November 29, 2024

**Re: Response to Technical Comments – SPC Application D07-12-24-0087; 2900 Brian Coburn Blvd./119 Ryan Reynolds Way**

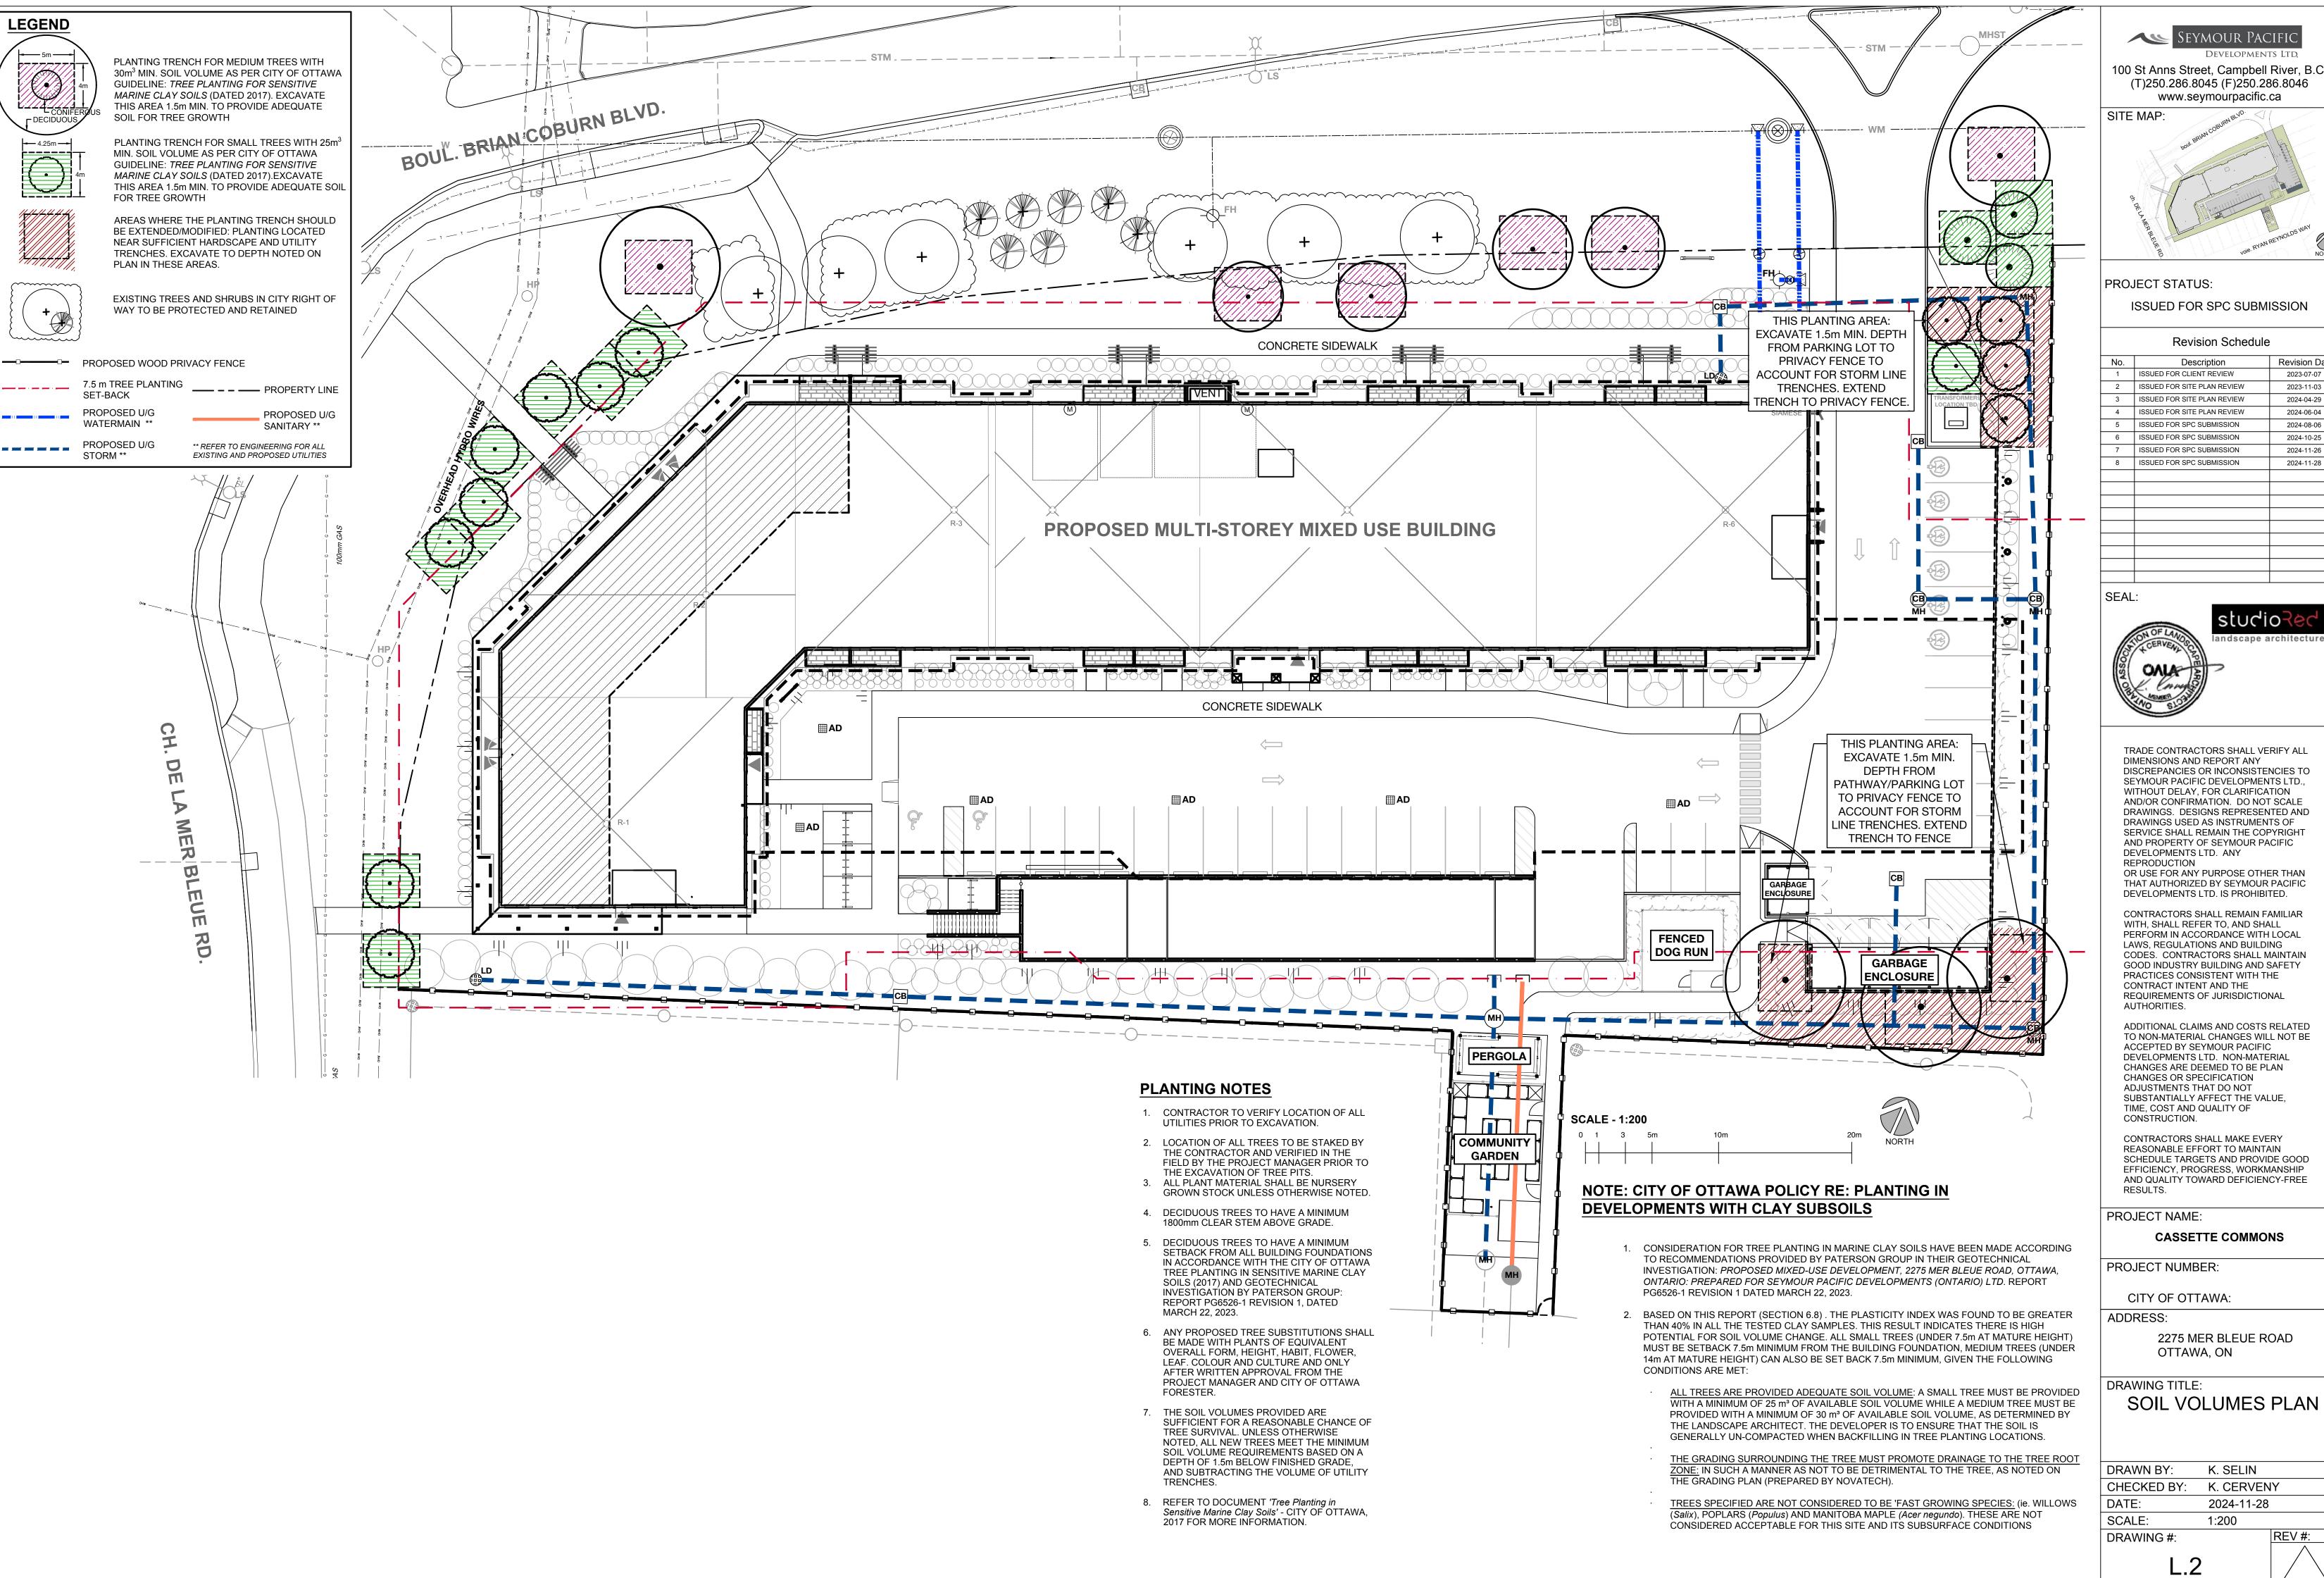
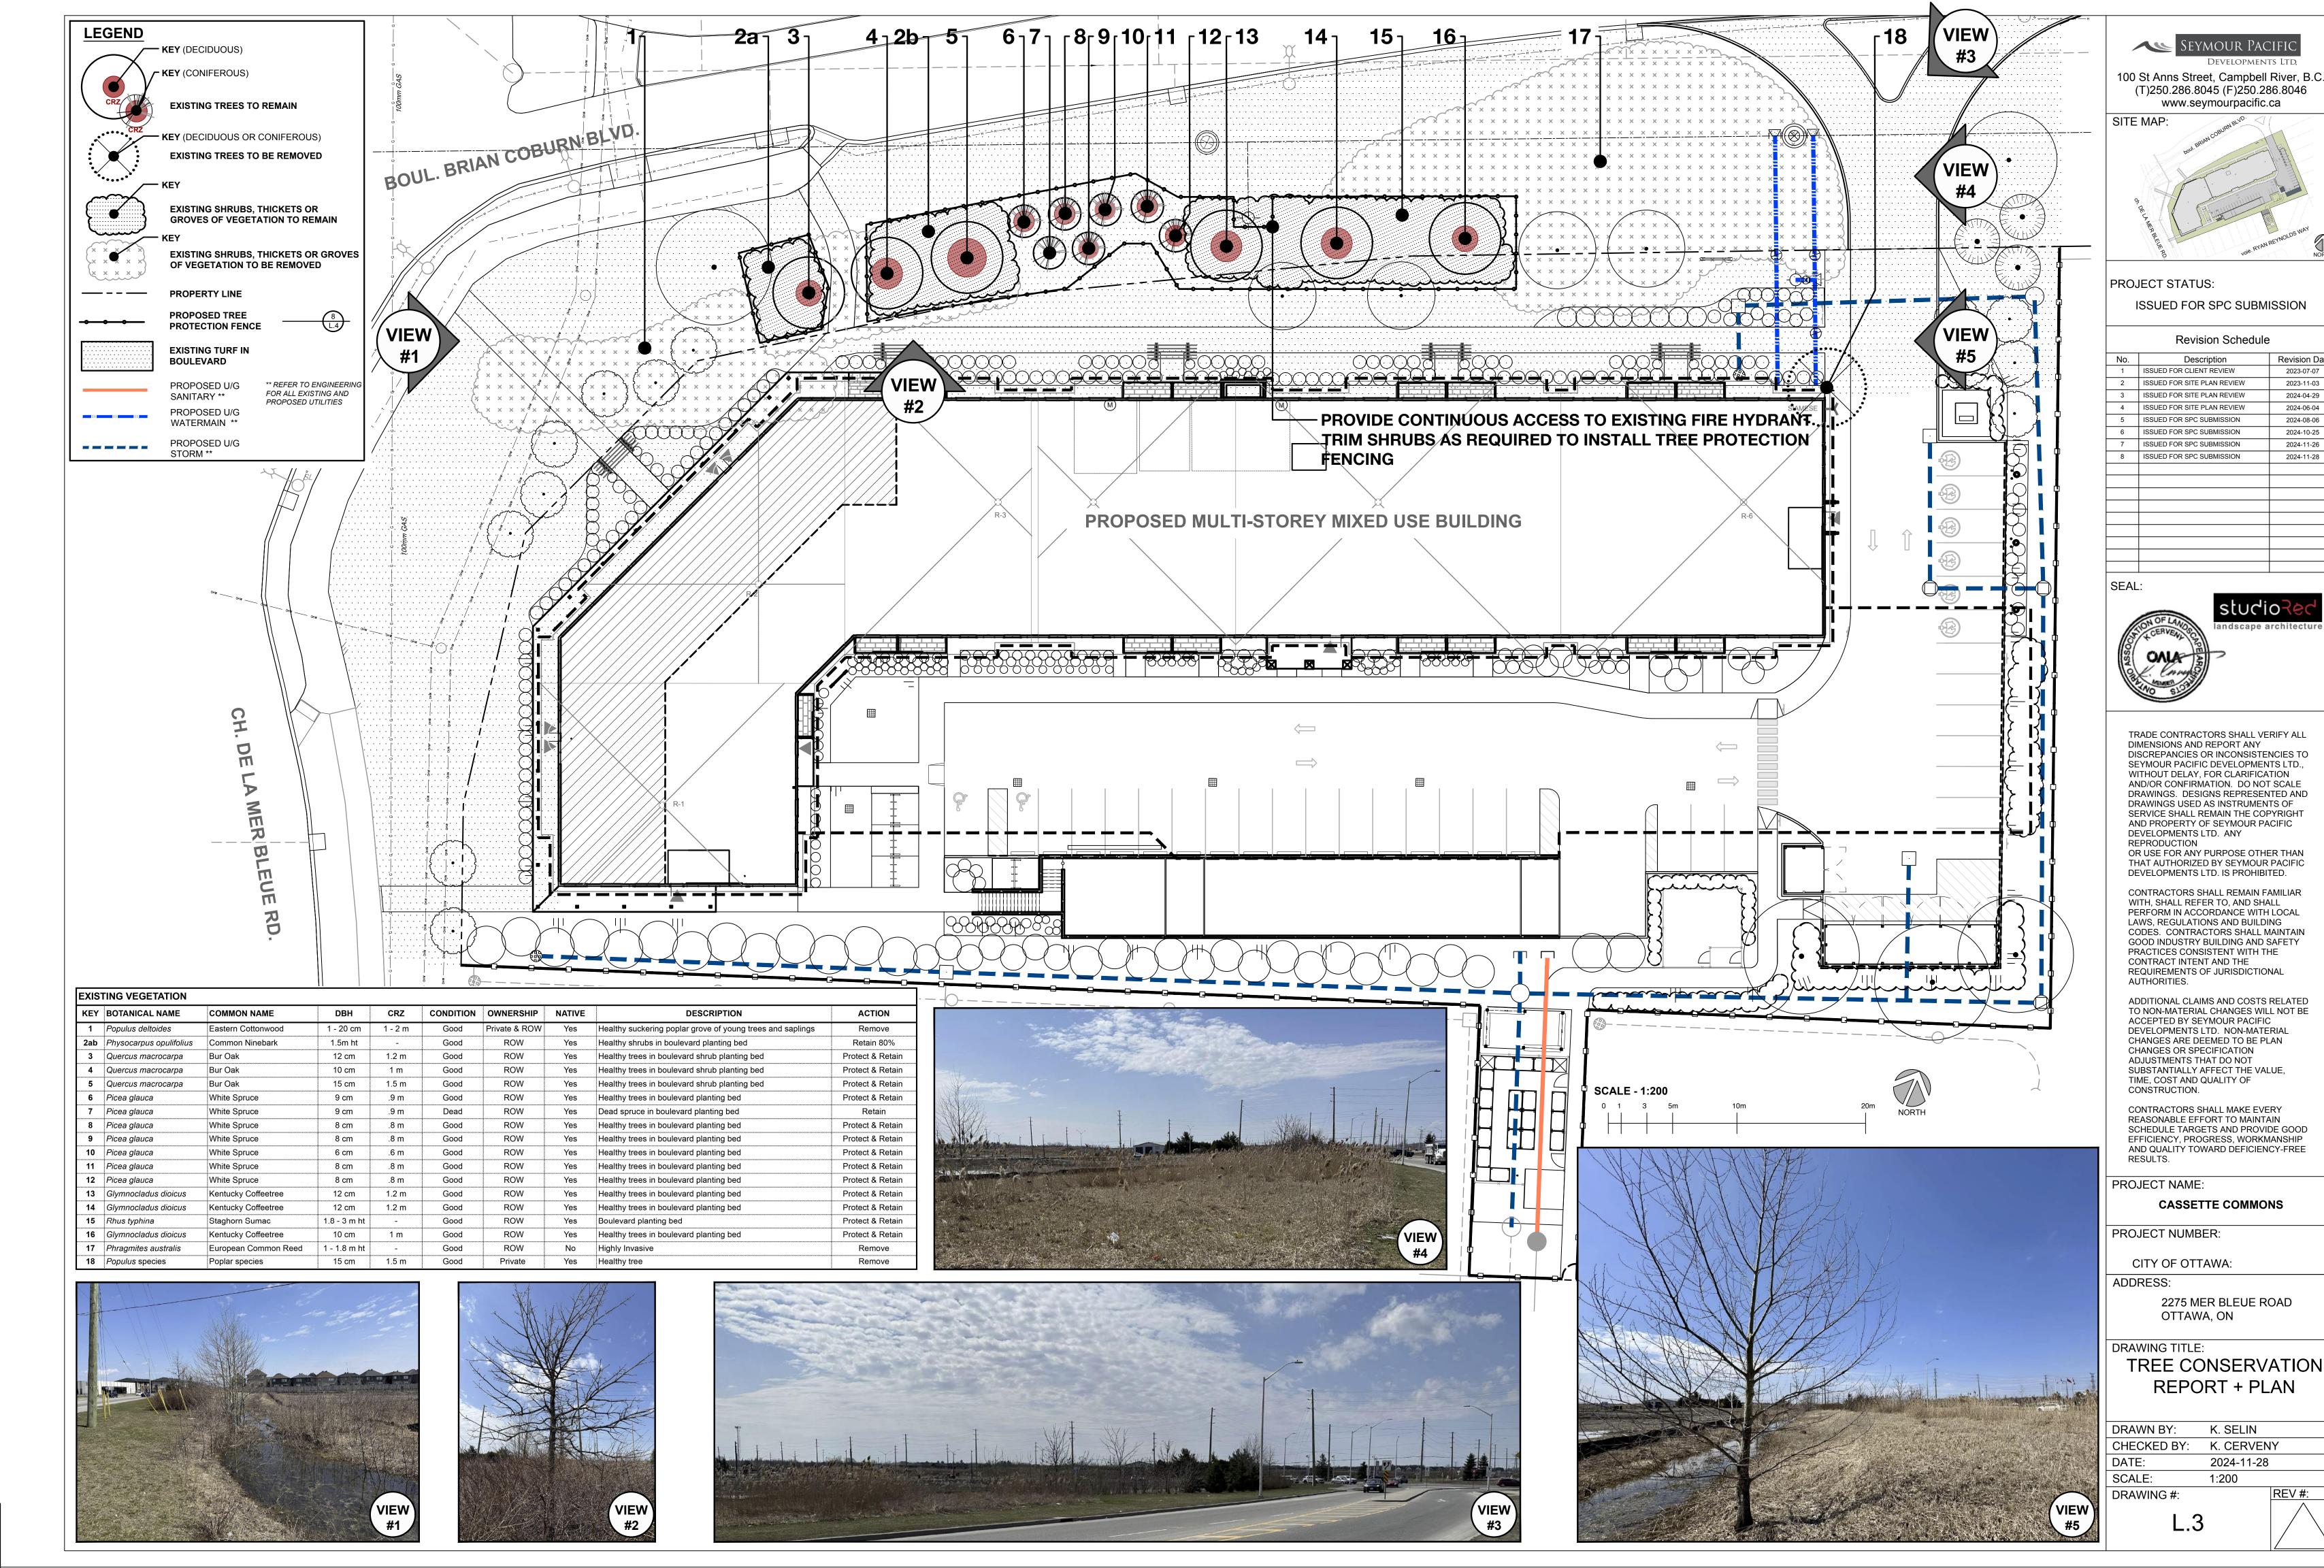
3. The private fire hydrant should connect to the private watermain to avoid multiple connections into the municipal infrastructure.	Noted. Please refer to the revised plans. The hydrant is now connected to the proposed service and isolated by valves such that the building feed can be disconnected while maintaining flow to the hydrant.
<b>II. Forestry</b>	
Comments:	
<p>4. Why doesn't the tree planting setback apply to the south side of the building? There is less than 7.5m from the trees to the building in this area. Photo included for reference:</p> 	The tree planting setback does apply so all proposed trees have been replaced by native shrubs.
